# CITY OF ALBUQUERQUE

June 13, 2022

**Re: Volcano Mesa Subdivision  
Erosion and Sediment Control Plan  
Engineer's Stamp Date: 6/3/2022 (C09E001H)**

# Temporary Erosion and Sediment Control Plan

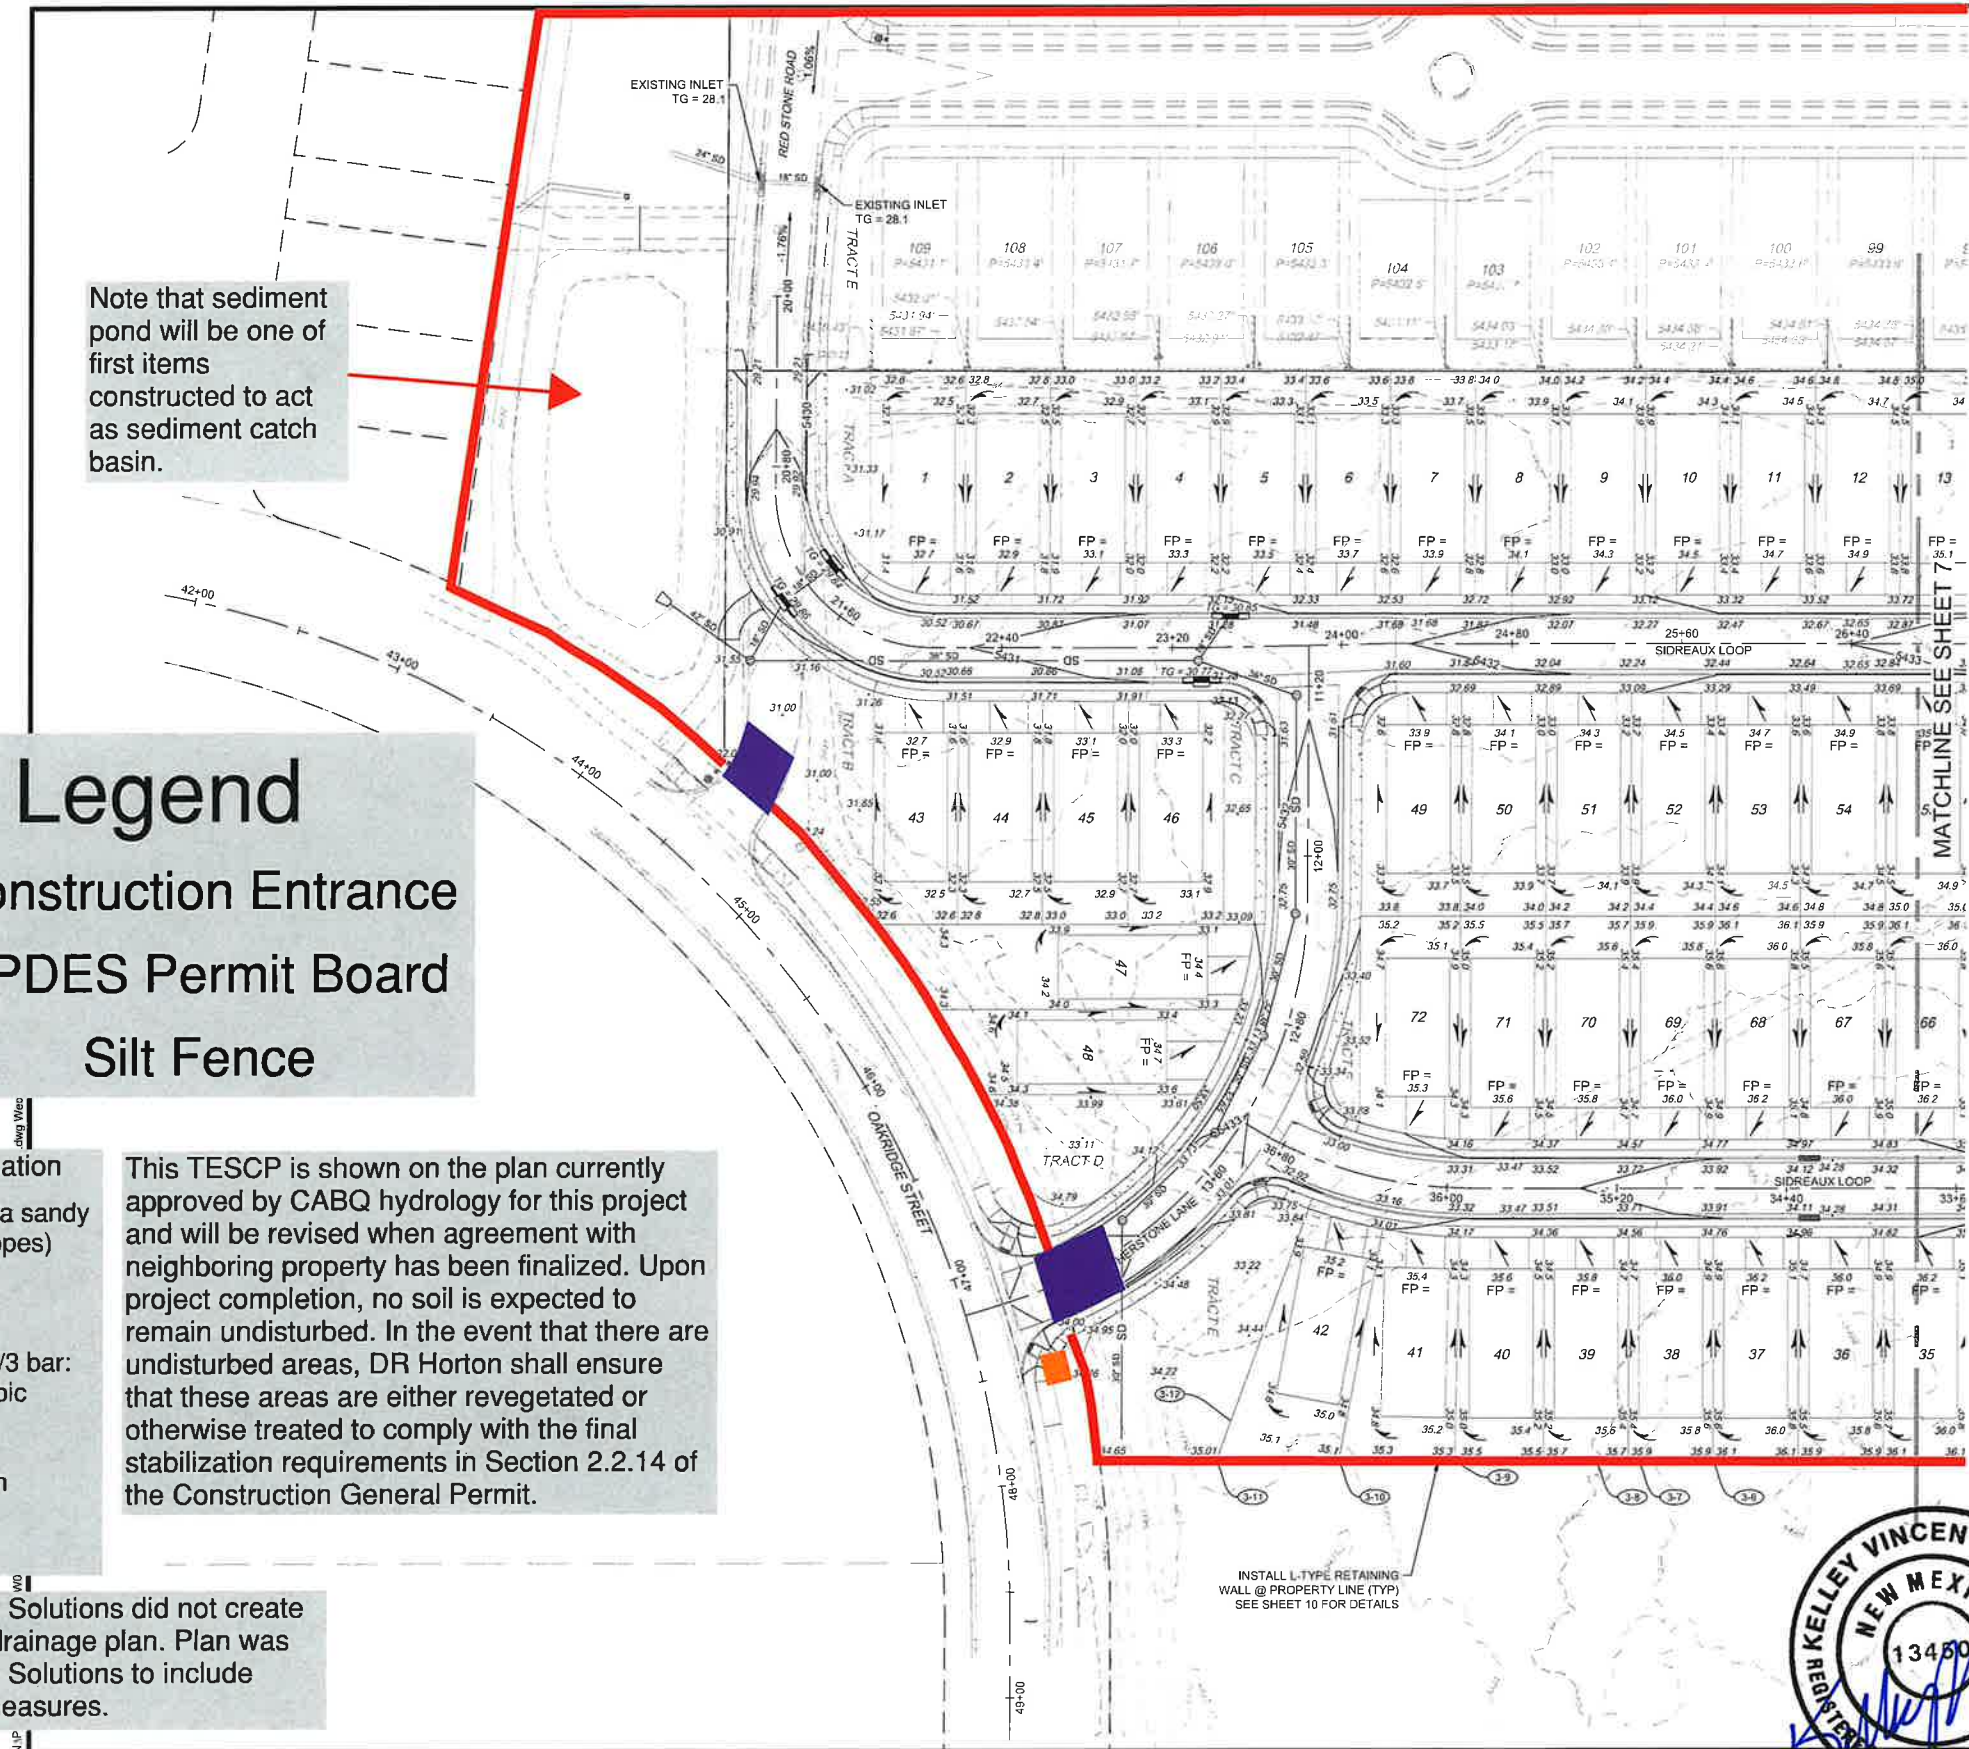
1. The Silt fence is depicted on other peoples property that is not a part of this project. Specifically no grading is proposed in the existing pond south of DR Horton's property and Property and no grading is proposed on the adjacent development west of DR Horton's property.

2. The limits of disturbance is not indicated on the plan. Add a symbol to the legend and identify the limits on the ESC plan.
3. Describe the nature and extent of construction activities (CGP 7.2.2.) Describe the nature of construction activities beginning with the initial establishment of the BMPs, posting of permit coverage, and any demolition covered by the permit. Describe the transition from subdivision infrastructure construction under the Work Order (WO) to the home construction under Building Permits (BP) and identify BMPs and contractors in control of the site during WO phase and BP phase. Include a description and project schedule per CGP 7.2.3.f through final stabilization, sale of the lots, removal of BMPs, and filing NOT. Also note the size of the property and the total area of land disturbing activities.

4. Cutback Swales, or some other form of perimeter control, must be shown on the ESC Plan along the frontage for Building Permit (BP) approval. The BMP should be established by the developer near the end of the grading and construction of the public infrastructure, then it should be maintained during Build Permit by the home builder. DR Horton is both the developer and the home builder CGP 2.2.3.

5. Describe the Stormwater Controls per CGP 7.2.6. Include BMP construction details, and specifications and a schedule on the ESC Plan and in the SWPPP.
6. How will the HOA Tracts be stabilized? Will they be Stabilized by DR Horton or the HOA? Please provide landscape plans and specification if available and include them in the SWPPP (CGP 7.2.6.b.vi and 9.4.1.c.i).
